Case Officer: Linda Griffiths

Proposal: Discharge of condition 10 (Drainage) of 14/01932/OUT

DATE: 15 March 2021

CLIENT	L&Q ESTATES
PROJECT	WYKHAM PARK FARM, BANBURY
TITLE	PROPOSED SWALES TYPICAL SECTIONS
HYDROCK PROJECT NO.	C-04841-C
SCALE @ A1	AS SHOWN
PURPOSE OF ISSUE	SUITABLE FOR INFORMATION
STATUS	S2
DRAWING NO. (PROJECT CODE-ORIGINATOR-ZONE-LEVEL-TYPE-ROLE-NUMBER)	WPF-HYD-XX-XX-DR-C-2101
REVISION	P4

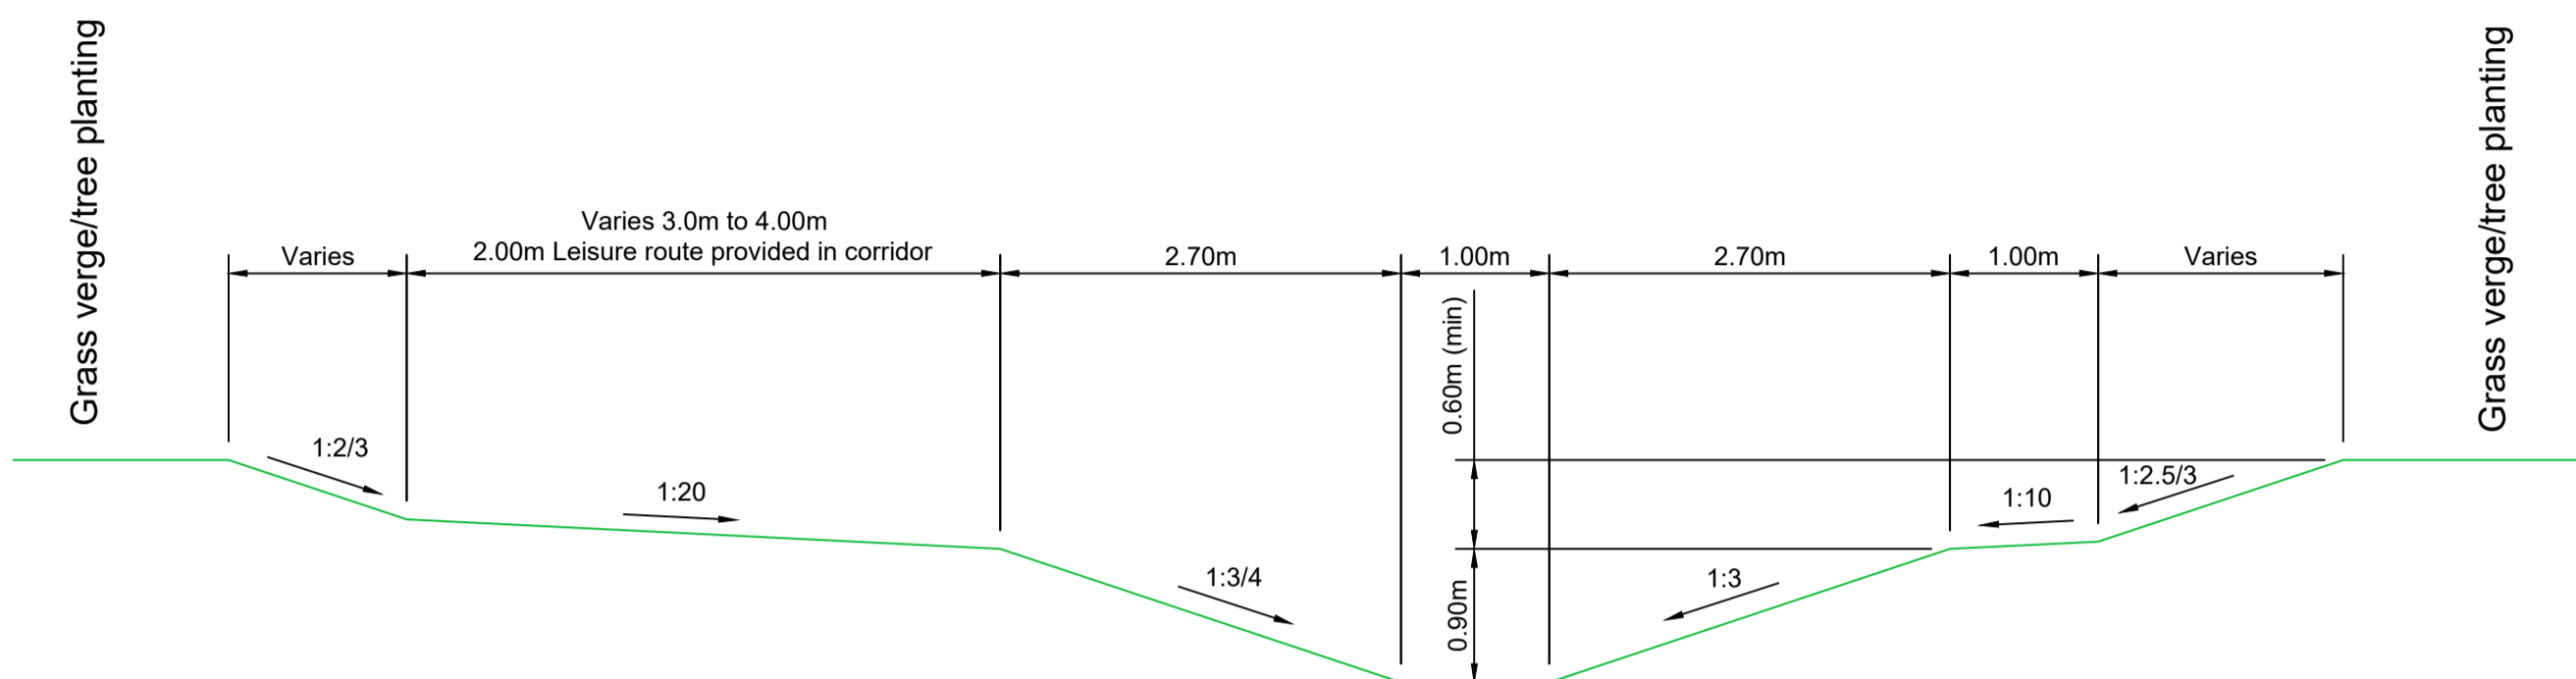
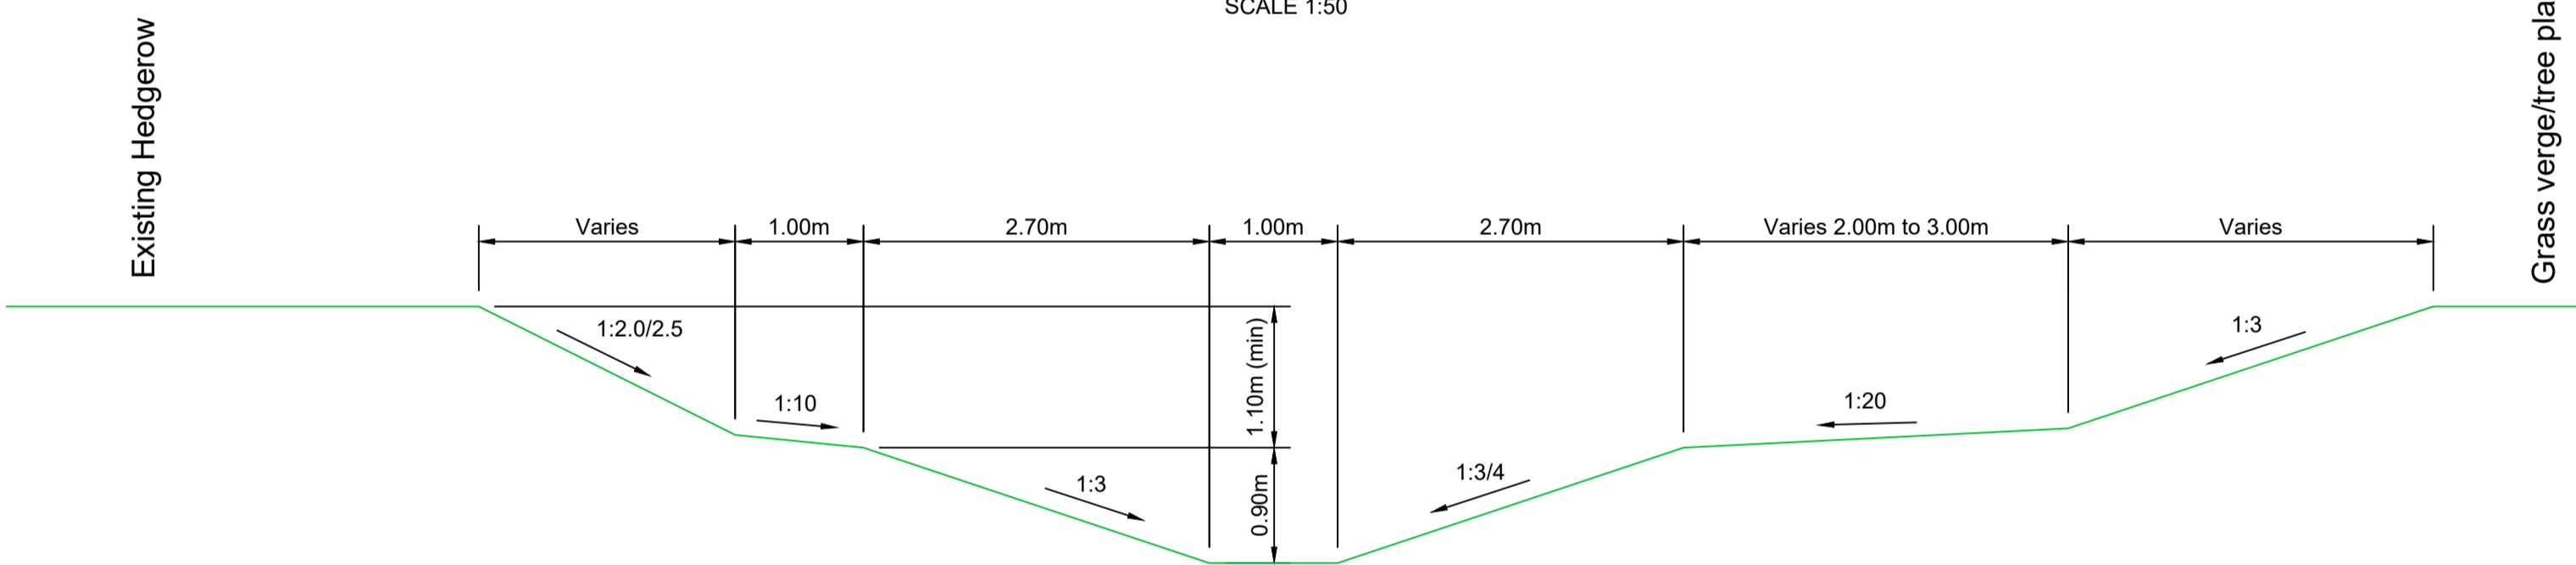
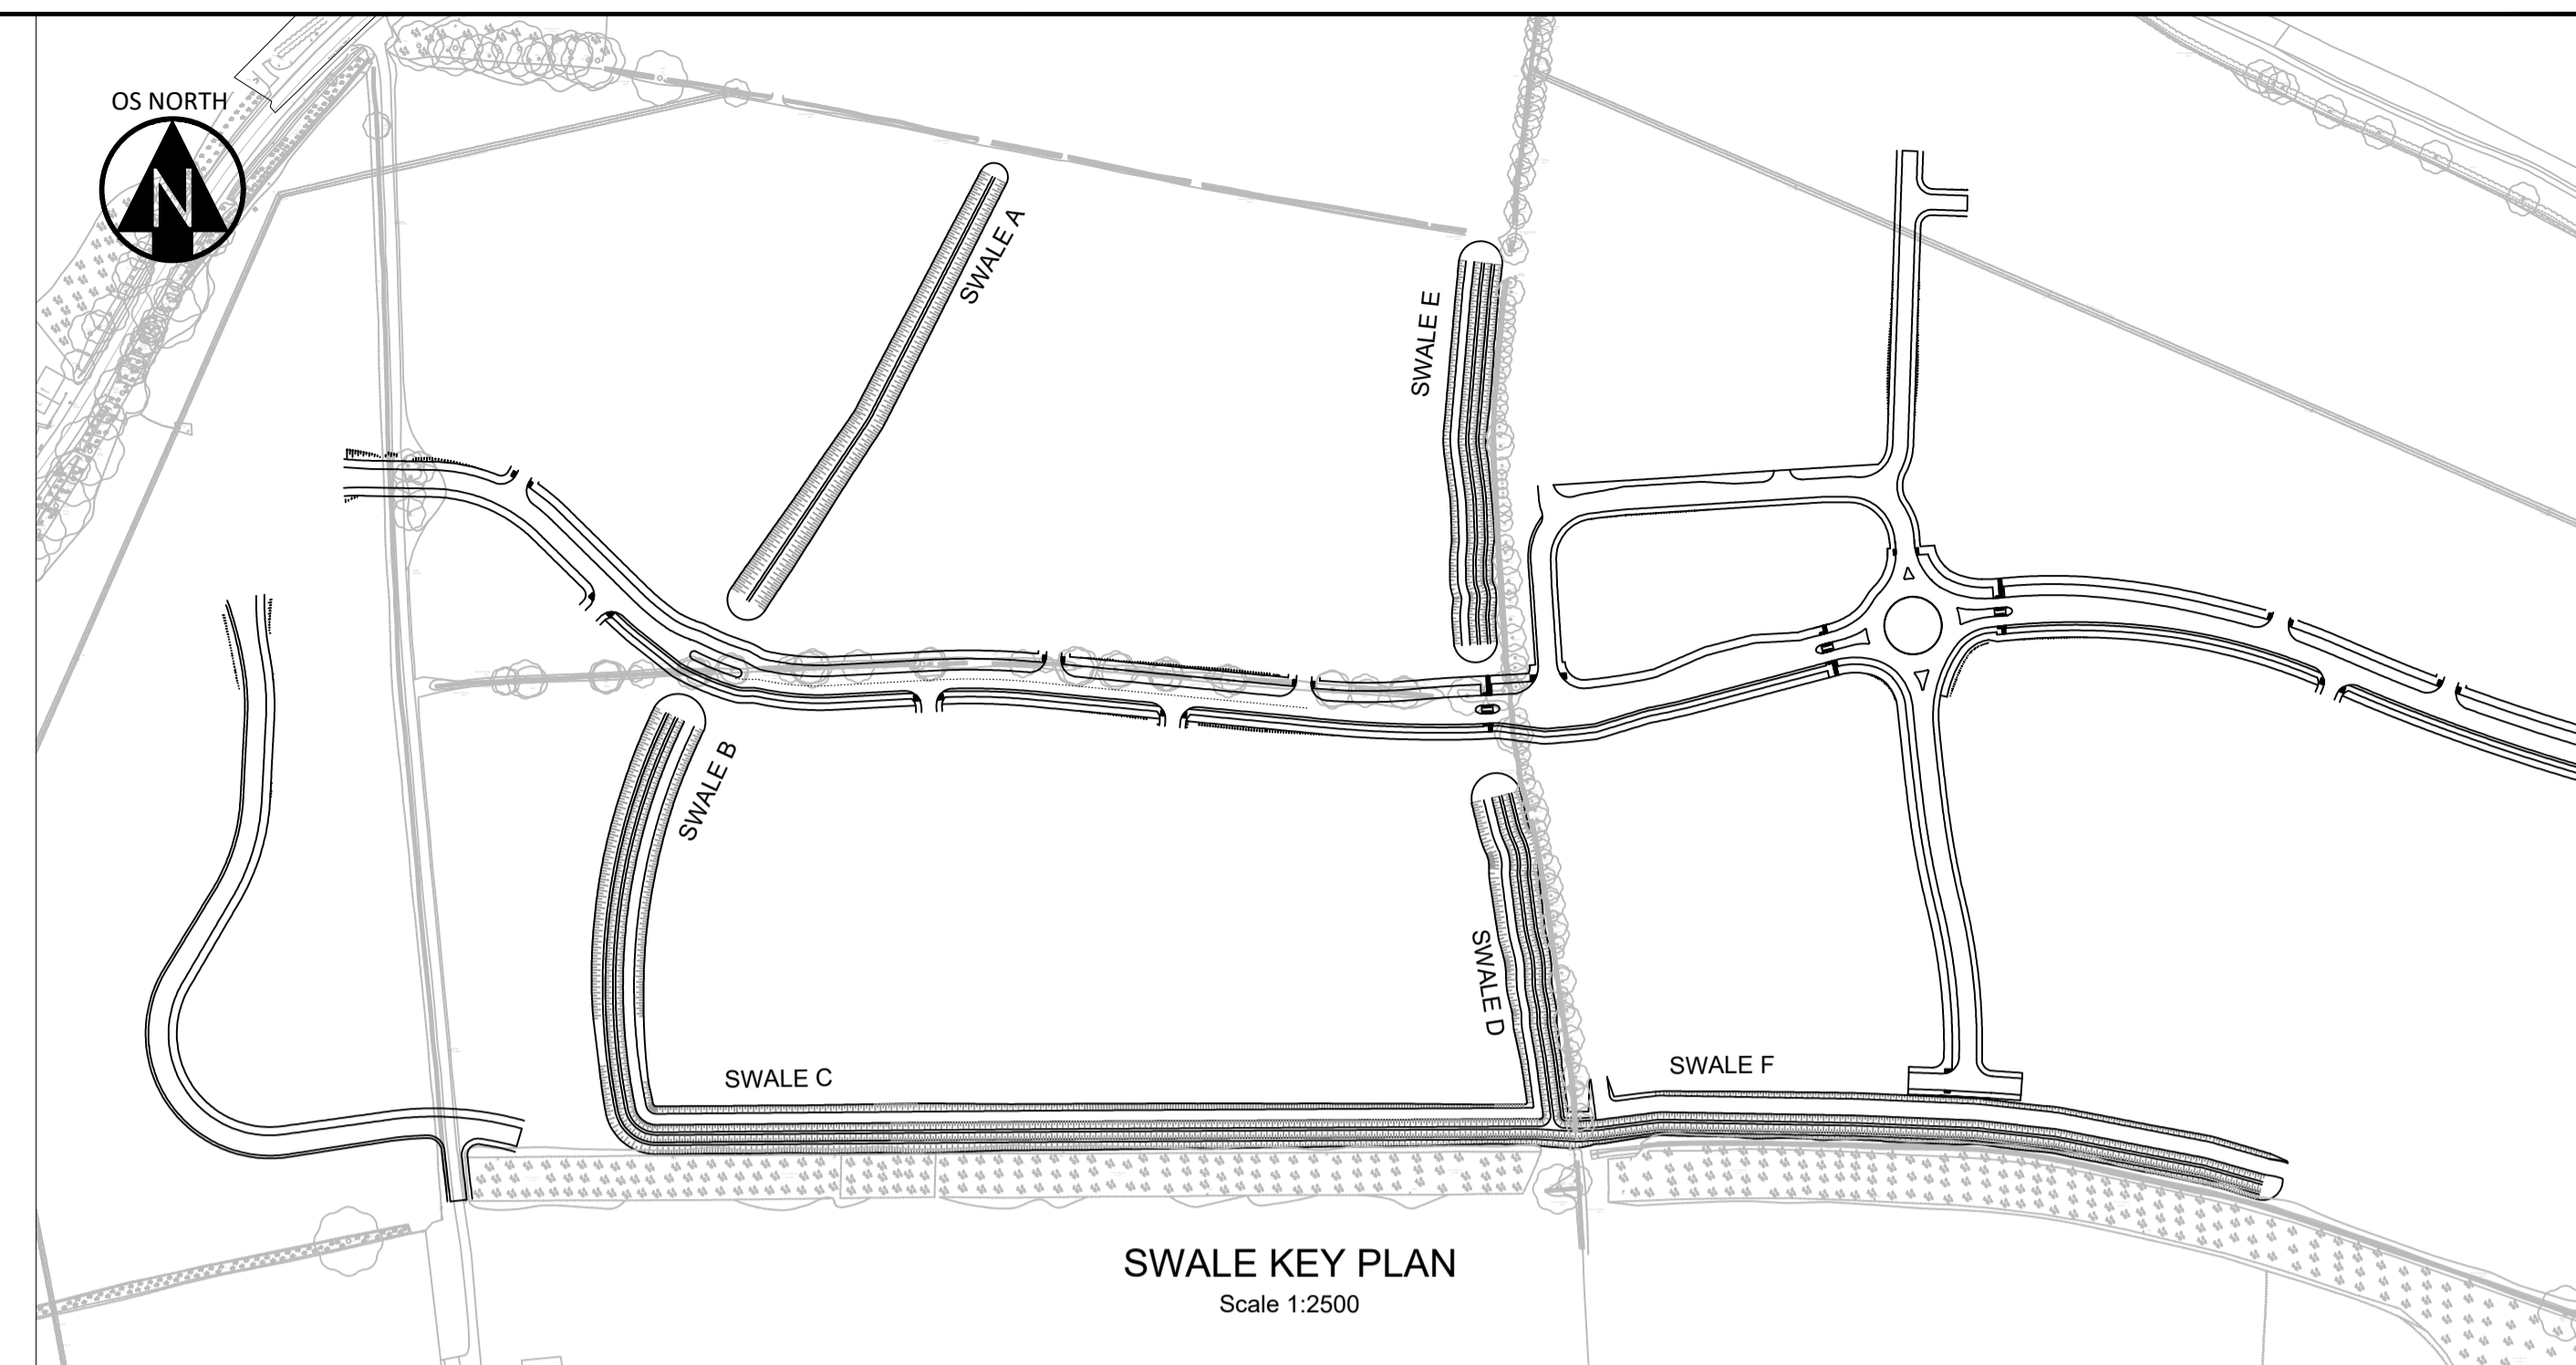
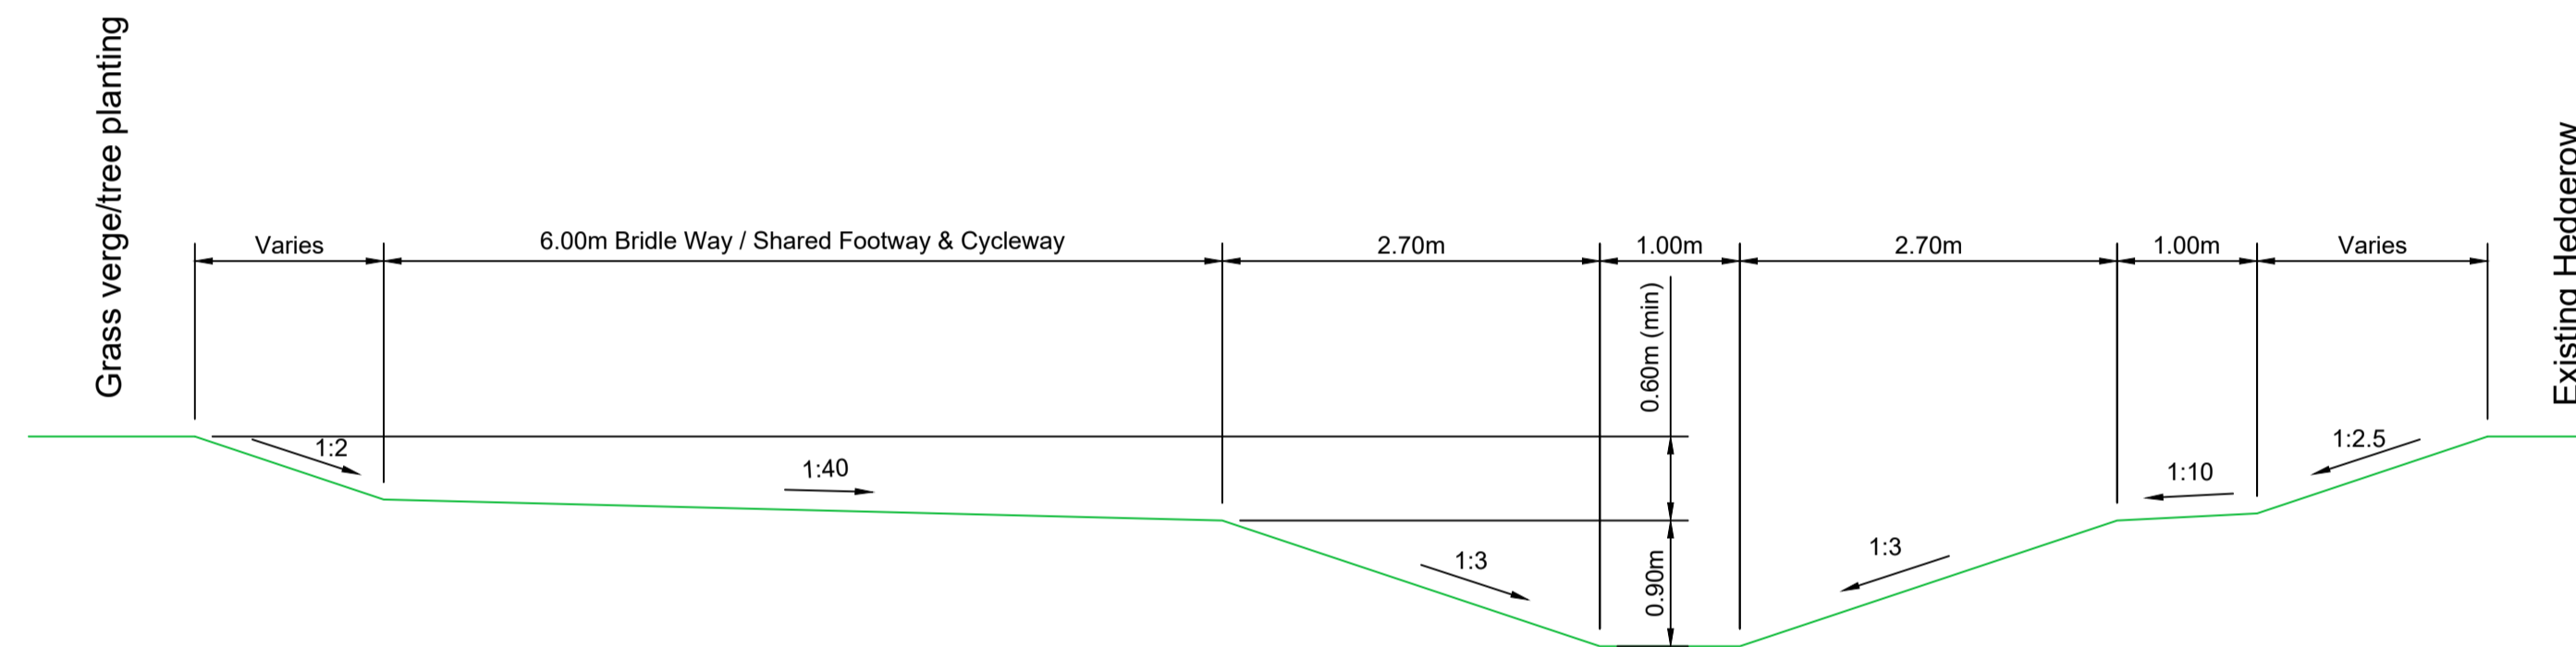
- 6.4. In terms of landscape and appearance, the swales proposed originally were all channels with regular sides and a single profile whereas there is an opportunity to create far more variety in terms of width, profile and depth in order for the drainage to appear more natural, be safer for children and provide improvements for biodiversity. It was also considered that the basins were very regular in shape and an uninteresting, engineered solution. The applicants were advised that the basins and swales needed to be designed alongside the landscape and biodiversity strategy. Furthermore, the details submitted here did not appear to correspond with the emerging Design Code in terms of their profiles and designs. This issue has since been addressed.

ATTENUATION BASIN A SECTION  
SCALE 1:250

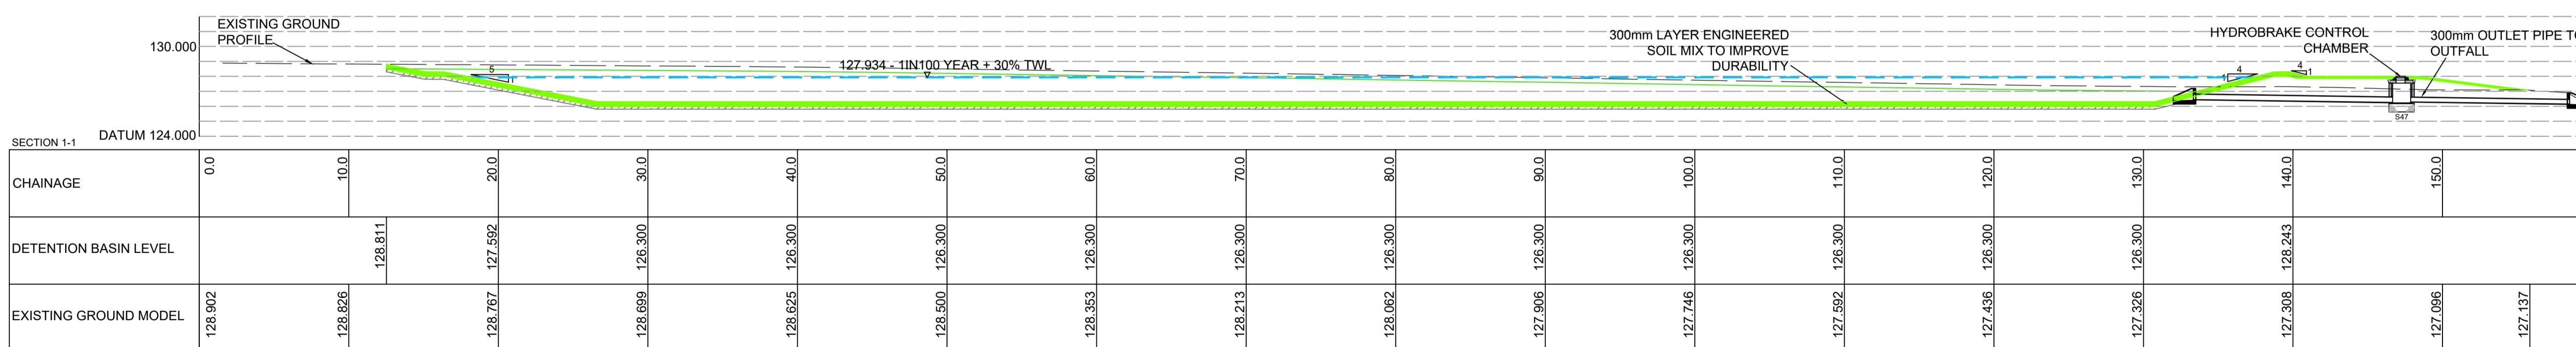
- 4.1 CDC Arboriculture: No comments to make.
- 4.2 CDC Ecology: No comments received.
- 4.3 Environment Agency: No objection to discharge of condition.
- 4.4 CDC Landscape: number of concerns raised about the quality of the resultant swale and attenuation profiles proposed.

Update 14th December 2020: comments relating to depth of balancing ponds remain unchanged.

- 6.5. In terms of the slopes to the attenuation, the applicant's agent has advised that these cannot be reduced as this would result in the run-off margin for the sports pitches being reduced, or the size of the sports pitches reduced. It is considered that this would not be appropriate as it would compromise the delivery of the sports pitches as required by the Sec 106. The attenuation as set out is therefore accepted.

- 6.2. The detention basin is designed such that it does not hold a permanent body of water and will be designed to RoSPA standards and the edges will be defined through planting and landscape treatment. All batter slopes have been designed at 1:3 side slopes.
